## **FIRE RISK MANAGEMENT, INC**

# **Memo Report**

**From:** W. Mark Cummings, P.E.  
**To:** Ms. Katherine Detmer; Archetype Architects  
Mr. Bill Hopkins; Archetype Architects  
**Subject:** **Updated Fire Protection & Life Safety Code Review of the Brick South Building at Thompson's Point**

1 FLOOR PLAN
A1.01
3/32" = 1'-0"

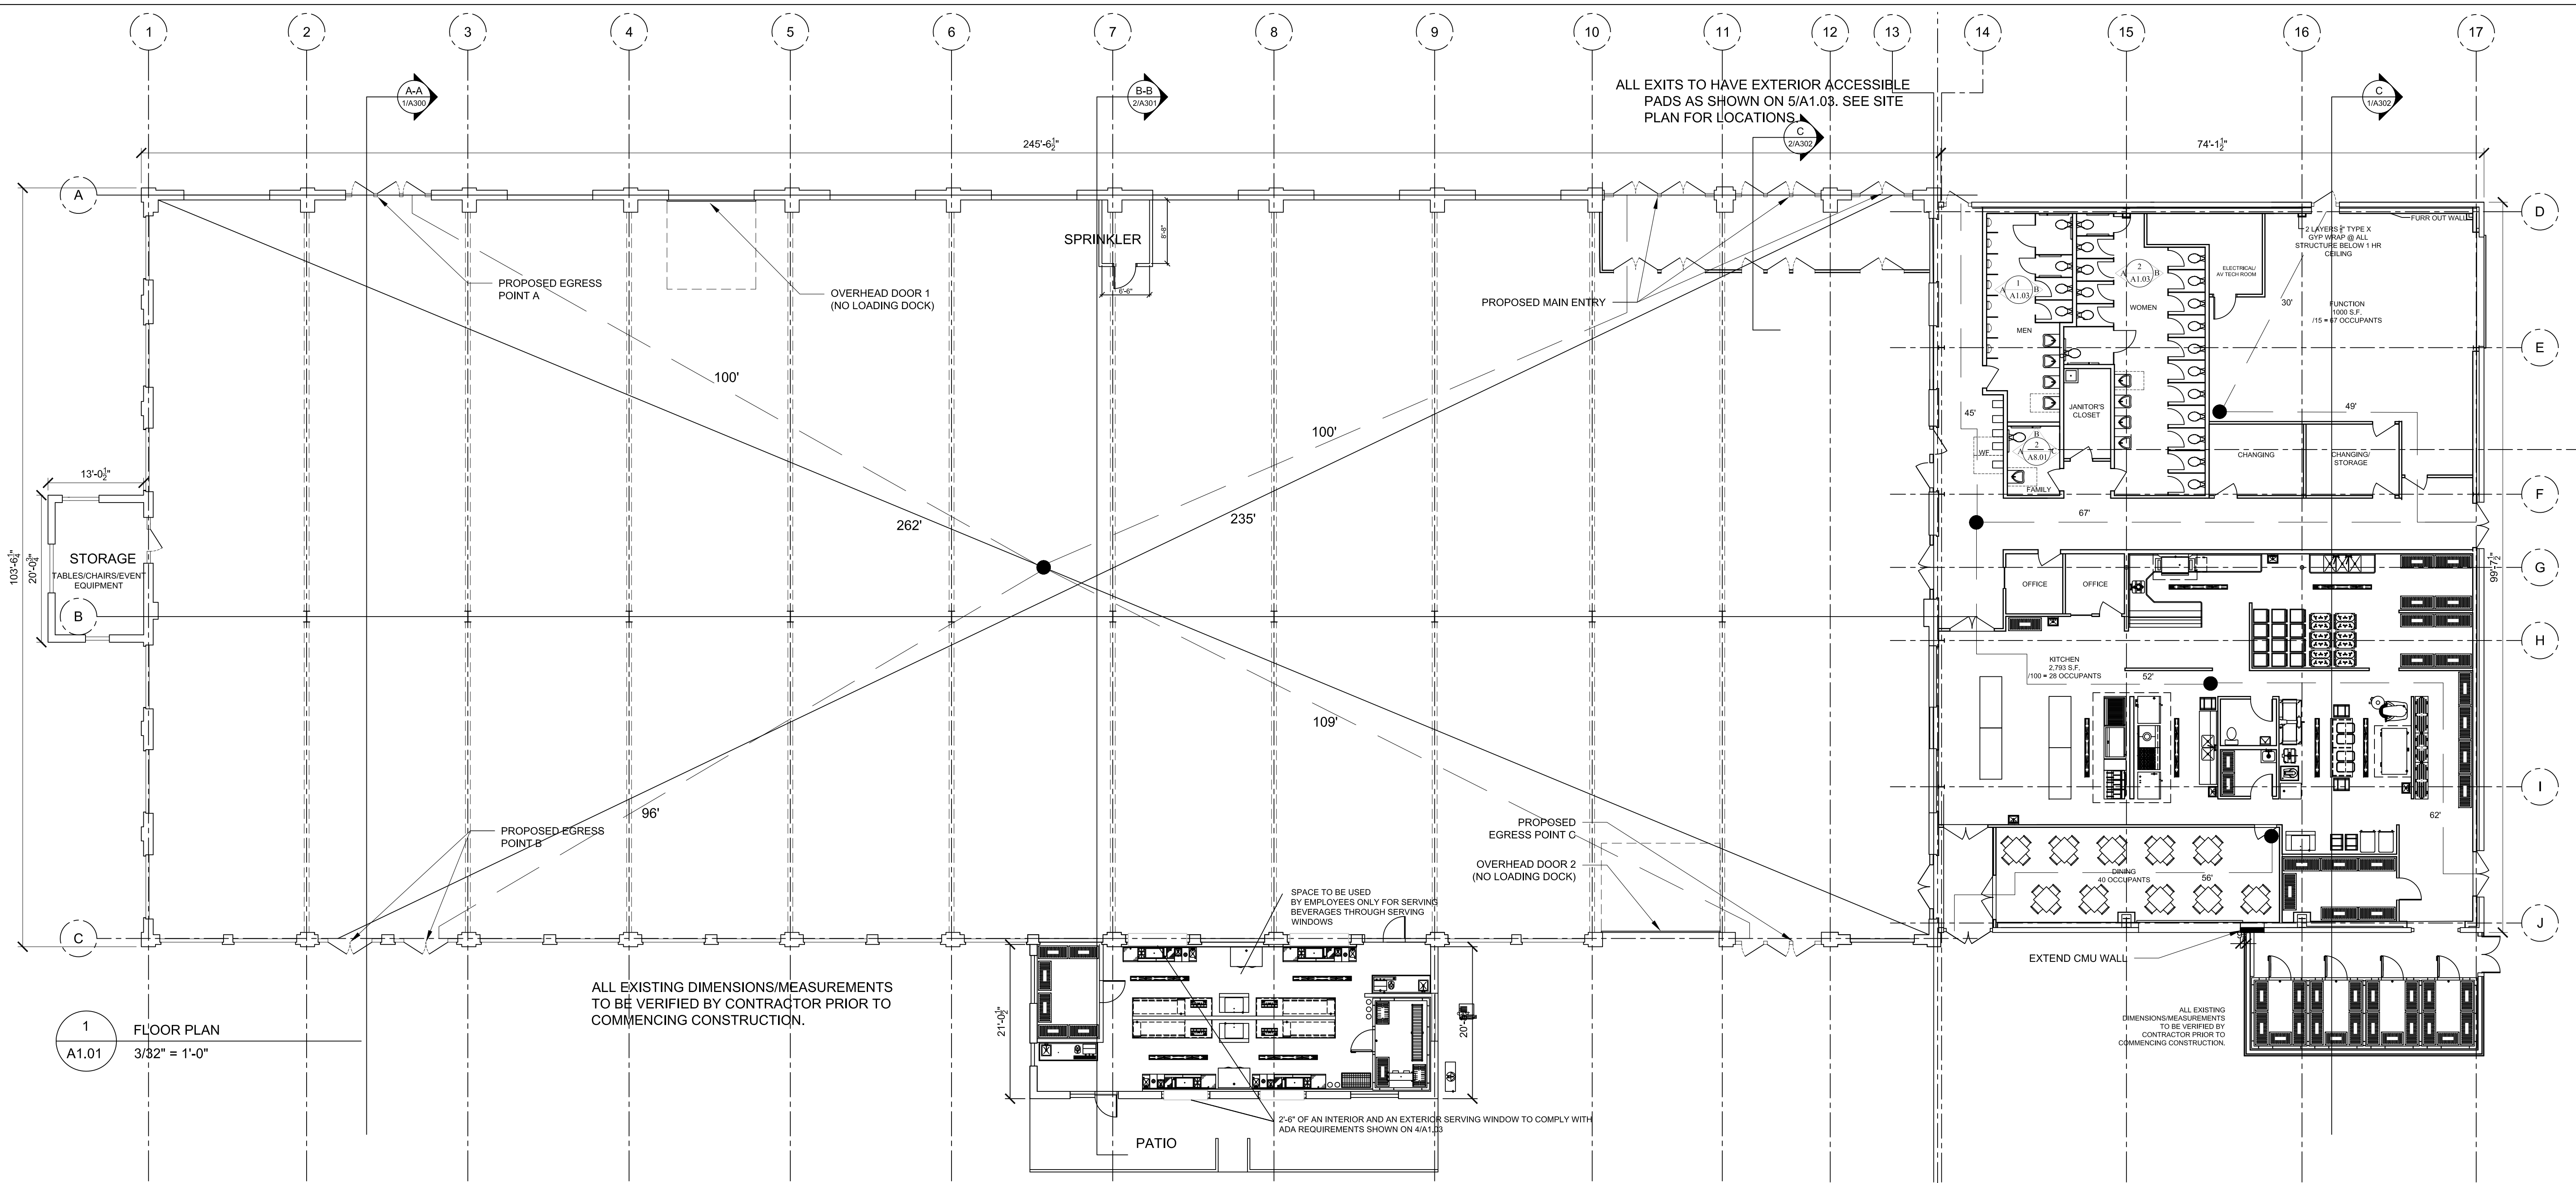
This review of the Brick South building focuses solely on the building itself and was conducted primarily using the Life Safety Code<sup>®</sup> and the MUBEC. The review is based on the Floor Plan and Elevation drawings provided by Archetype Architects on 08/31/16. It is understood that at this point in time, the building is to undergo renovations to modify its use as, primarily, an "assembly" occupancy; with the ability to accommodate a wide range of functions and events. Therefore, this building is to be classified as an "Assembly (A-3)" occupancy, per the definition outlined in the International Building Code (IBC). Equally, although the drawings provided indicate the potential to separate the main (west) portion of the building from the east annex section by a fire wall, it is understood this option is no longer to be pursued and the building is to be treated as a single structure / occupancy; with the areas within the annex portion being accessory to the main use.

Occupant Load: Based on the stated intended use for the building, the estimated maximum occupant load for the building would be approximately 3760 people; with the vast majority of this occupant load, approximately 3625 being within the large assembly area. However, it is reported that the building owner has stated that the maximum occupant load for the building is to be restricted to 2500 persons.

Based on the stated maximum occupant load, the building will be required to have at least four (4) separate exits. However, due to the potential occupancy load for the main assembly area, this area alone is also required to have at least four (4) separate means of egress.

Based on the estimated occupant load for the building, a total (clear) exit width of at least 500 inches (approx. 42 ft) must be provided by the available means of egress (exits). Since the planned occupant load for just the main assembly space has not been specifically defined, it will be assumed that this space alone must provide sufficient egress for up to 2500 persons. Assembly occupancies also have specific requirements to provide a "main entrance." This main entrance is required to have a capacity that can accommodate at least ½ of the total occupant load, per NFPA 101 § 12.2.3.6.2 (2). As such, the main entrance to the main Assembly area will be required to provide at least 250 inches (approx. 21 ft) of clear exit width. The remaining 250 inches of clear exit width are to be distributed amongst the other three (or more) required exits serving the main assembly area. All other exits provided should be provided with a minimum clear exit width of at least 34 inches. Based on a review of the proposed design plan for the building, more than sufficient exits, and exit width, are provided for all areas of the building.

*Dead end corridor:* The maximum allowable length for any dead end corridor is 20 ft, per NFPA 101 § 12.2.5.1.3 and MUBEC 1018.4 for assembly occupancies. The current building design includes no dead-end corridors.

*Common path of travel:* The maximum allowable common path of travel for assembly occupancies is 20 ft, or up to 75 ft where serving less than 50 people; per NFPA 101 § 12.2.5.1.2. The only areas where common path of travel to a means of egress exists is in the small storage areas and restrooms. However, no common path of travel within the building will exceed the code limits.

*Exit access travel distance:* In buildings protected with fire sprinkler systems, travel distance up to 250 ft is allowed for Assembly occupancies, per NFPA 101 § 12.2.6.2. Based on the proposed design plan for the building, the maximum travel distance to an exit from any location within the building is well below the code limit.
